Kirklees Metropolitan Borough Council -
Development Management
Huddersfield, HD1 2JR

Reference: PA-0001630/01
Customer reference: 2026/90811
27 April 2026

Extension of hardstanding to increase area of parking and used car display

Trust Ford, St. Andrews Road Huddersfield Kirklees HD1 6RJ

CLIENT:	TrustFord
PROJECT:	TrustFord Huddersfield Proposed Extension of Car Parking Area St Andrew Road Huddersfield HD1 6RJ
TITLE:	Proposed Site Plan (Part) 1 of 2 & Existing Site Plan (Part)
SCALE:	1:200@A1
STATUS:	REV: E
JOB NUMBER:	AA05-01
DATE:	March 2025
DRAWN BY:

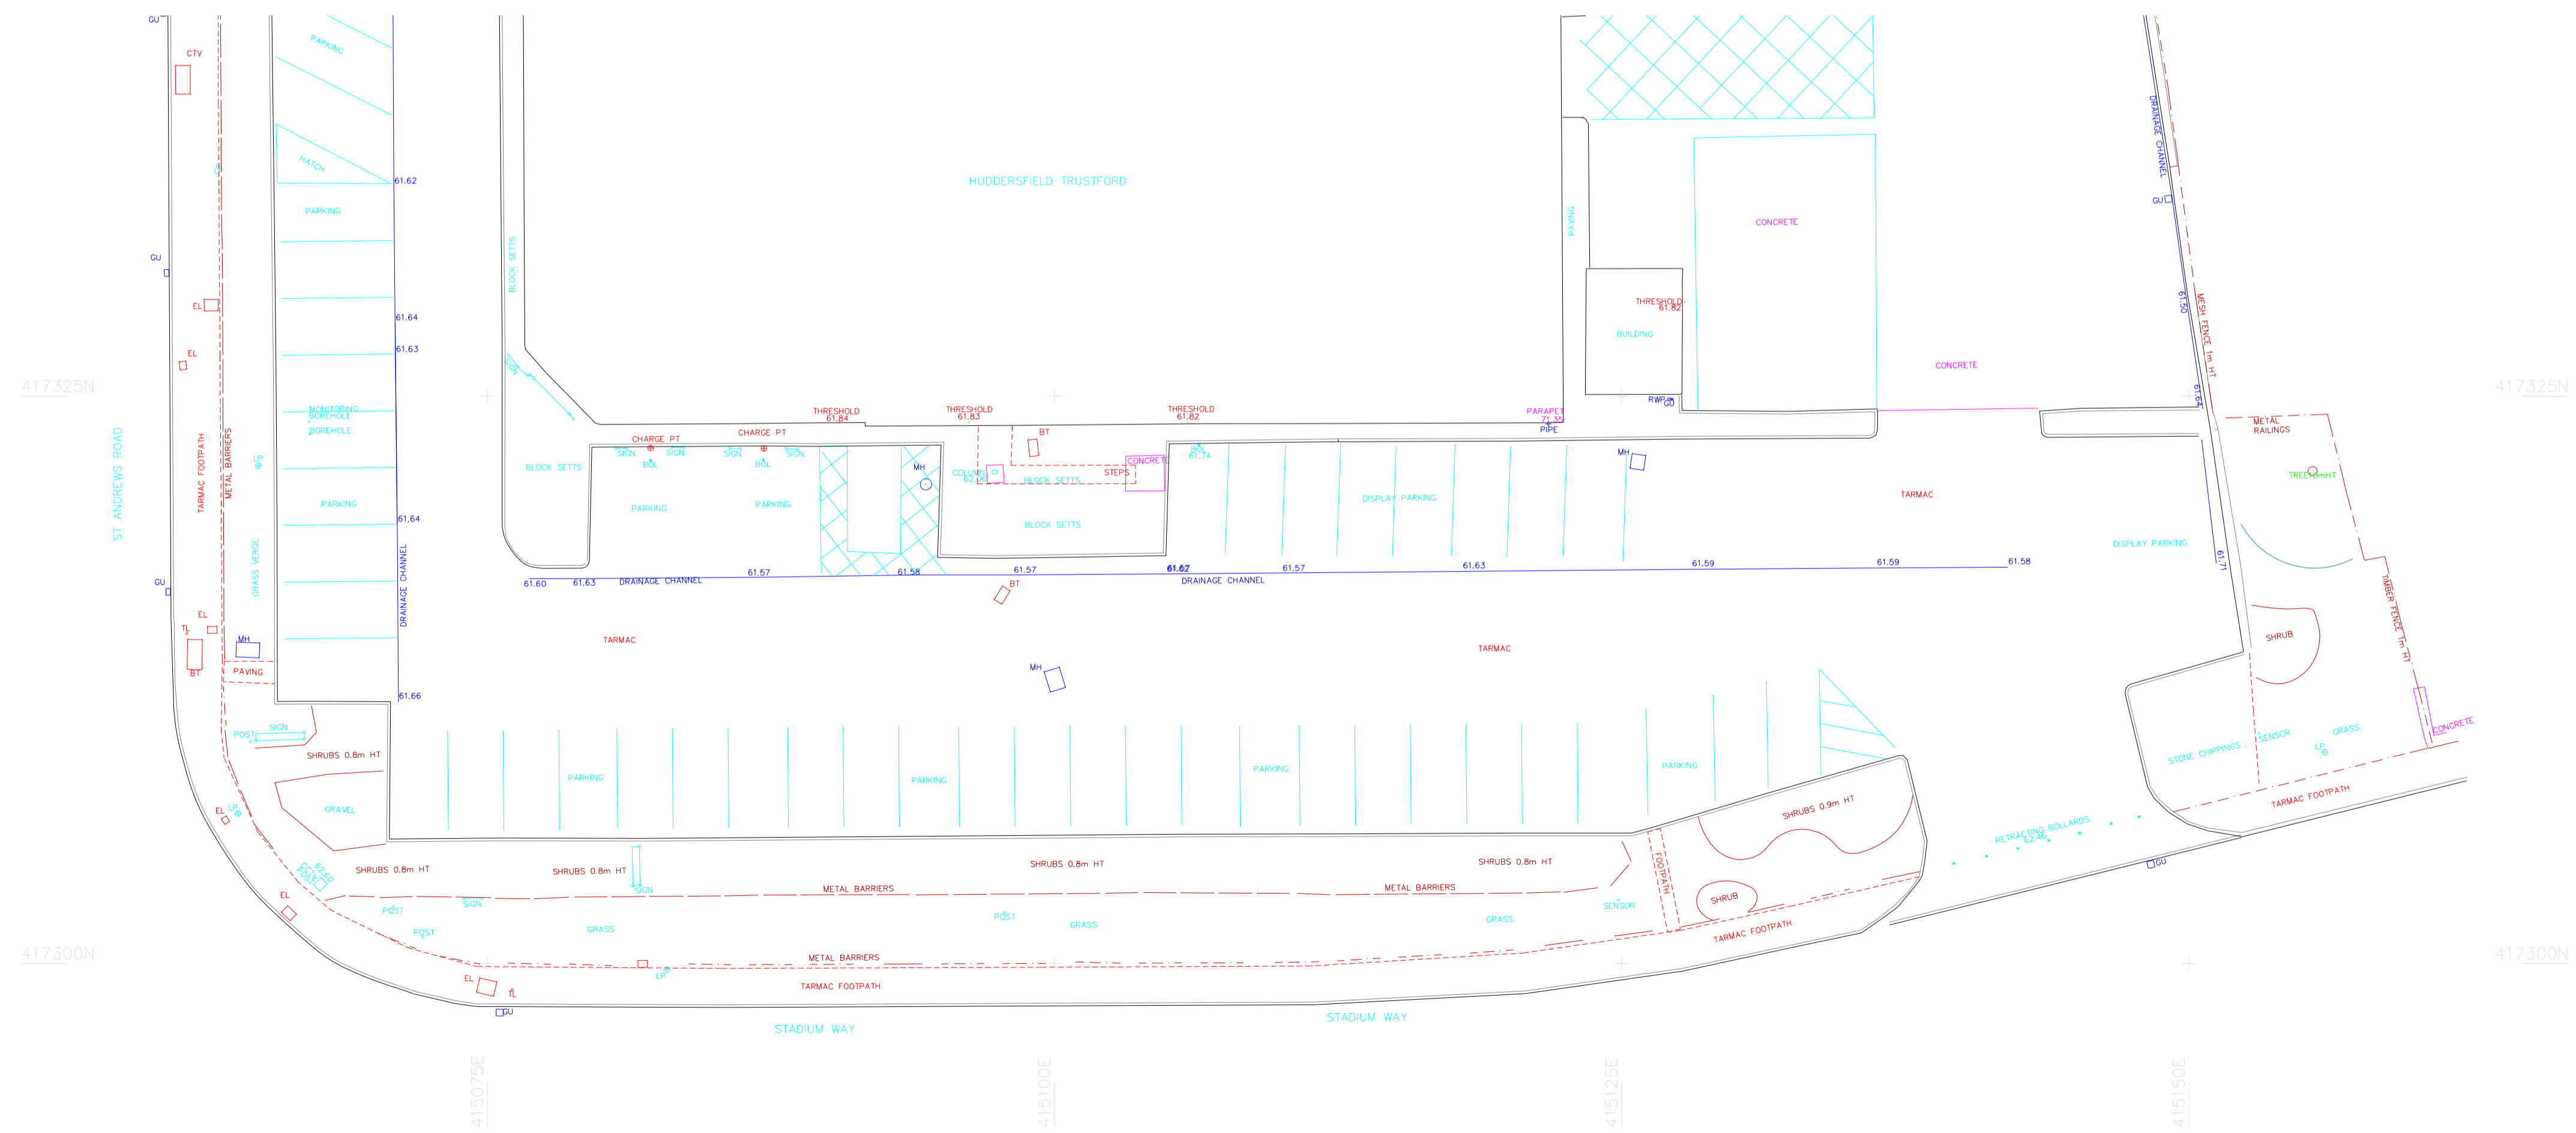
From the site layout plans (listed above) it is not clear whether the applicant will be extending the hard surfacing towards the river Colne and therefore increasing riparian encroachment at this site.

Additionally, the supporting documents provided do not adequately show that it will not have a detrimental impact on the watercourse, its corridor and associated physical habitats. Specifically, the riparian corridor.

It may be possible to overcome this objection if the Applicant submits revised plans that show:

- the location of the bank top on the site plan
- The extent of existing hard surfacing across the site
- The extent of vegetation and natural surfacing across the site
- Maintenance of the existing ecological buffer zone at the site. The buffer zone is measured from the bank top (defined as the point at which the bank meets the level of the surrounding land) alongside the River Colne (Colne from River Holme to River Calder, GB104027062550).

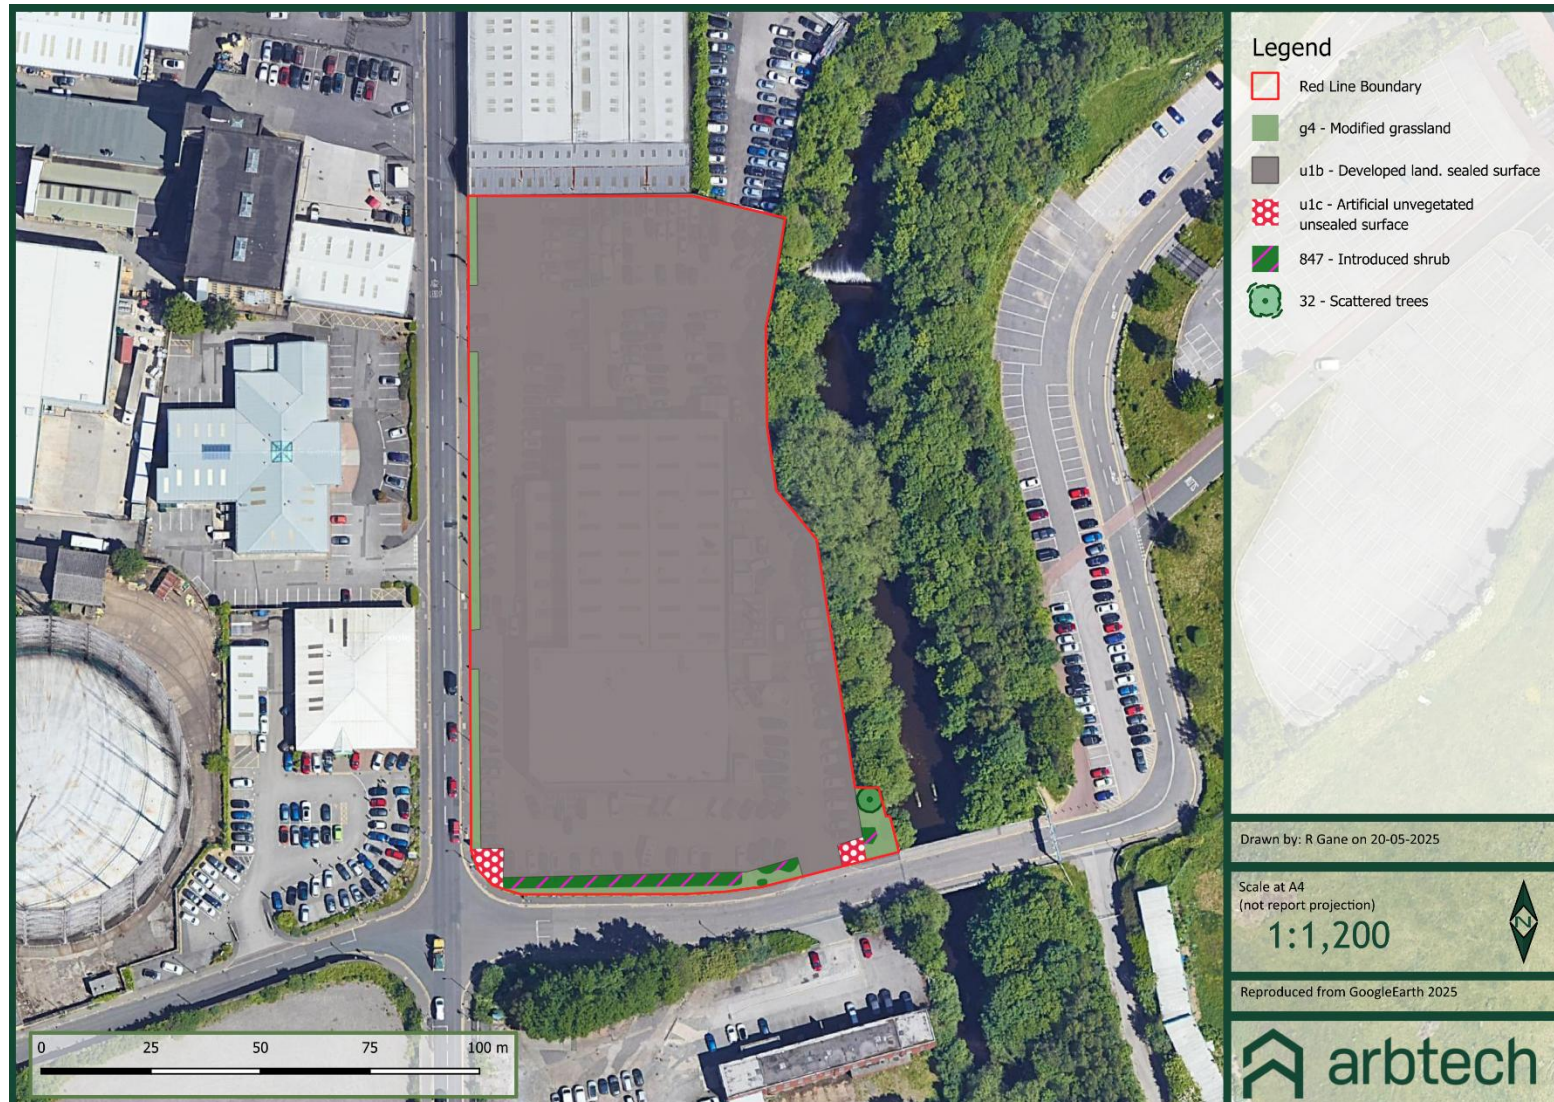
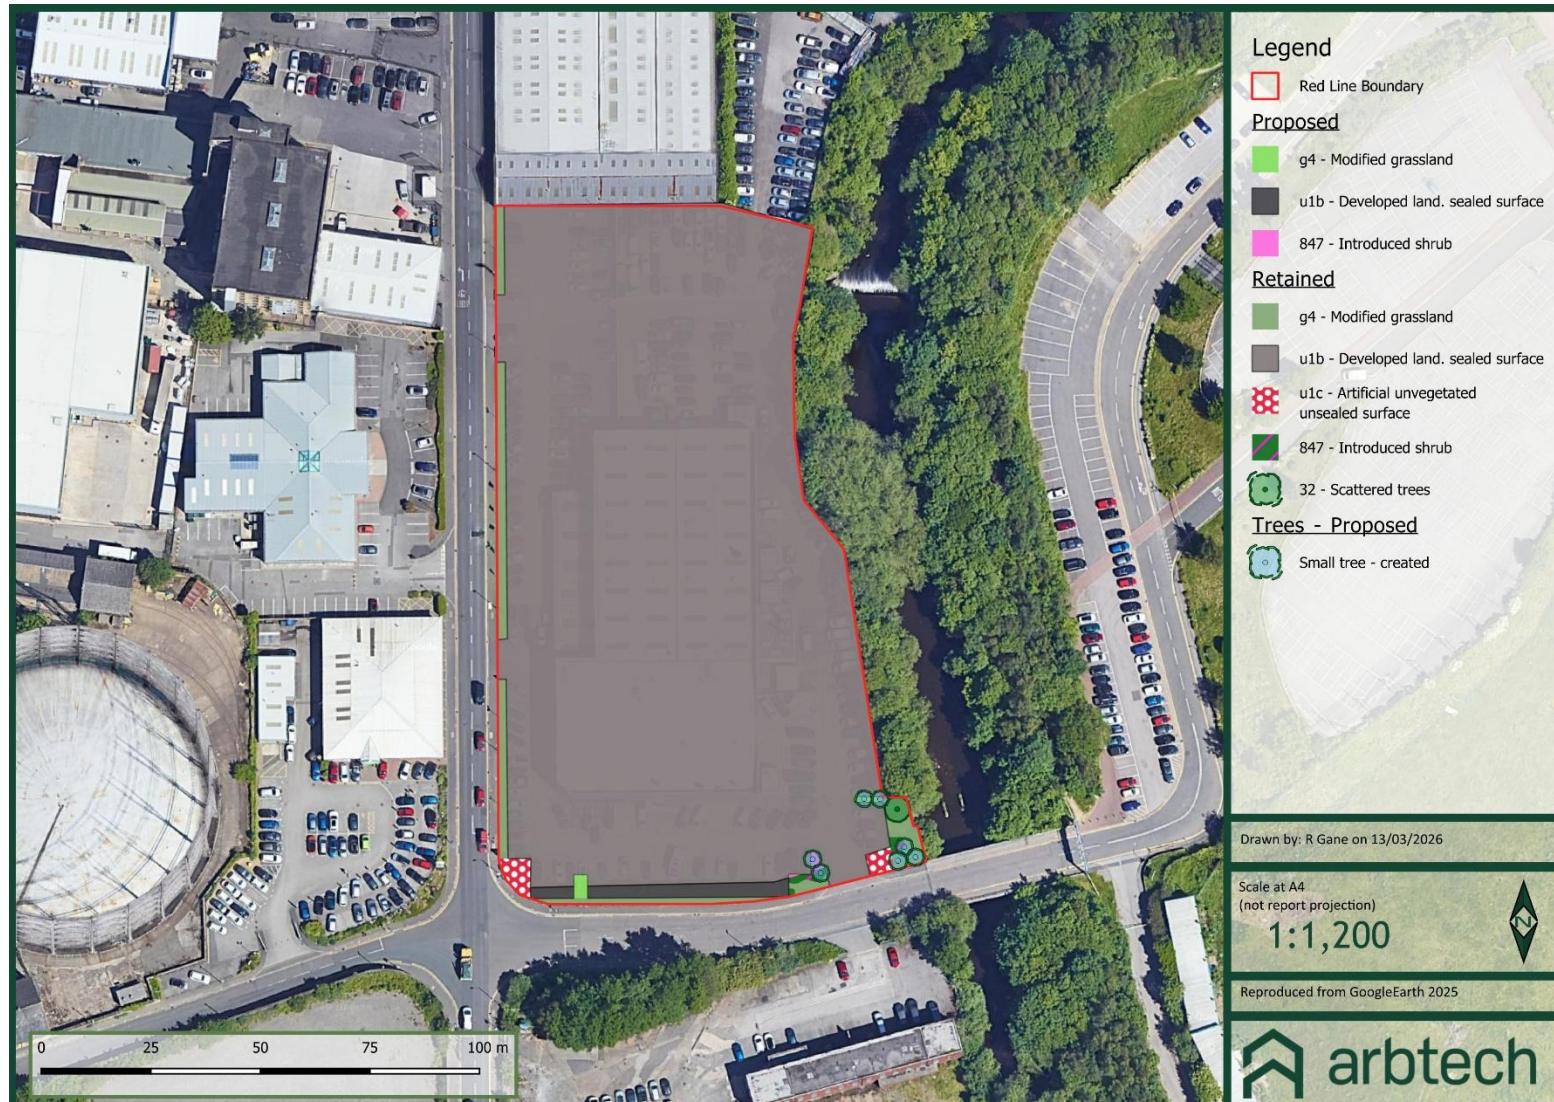
The Biodiversity New Gain assessment [Ecological/Biodiversity Statement [id 1132591] Size: 3.6MB 24/03/2026 - BNG - Trust Ford - V2 - HD1 6RJ - 13-03-2026] only accounts for Habitat Units. The red line boundary of the site appears to be within 10m of the bank top therefore we believe the applicant has missed Watercourse Units from their assessment. To meet the trading rules for this site, the applicant will be required to deliver 10% uplift in Watercourse Units. We recommend the LPA seeks an updated BNG assessment and metric calculation.
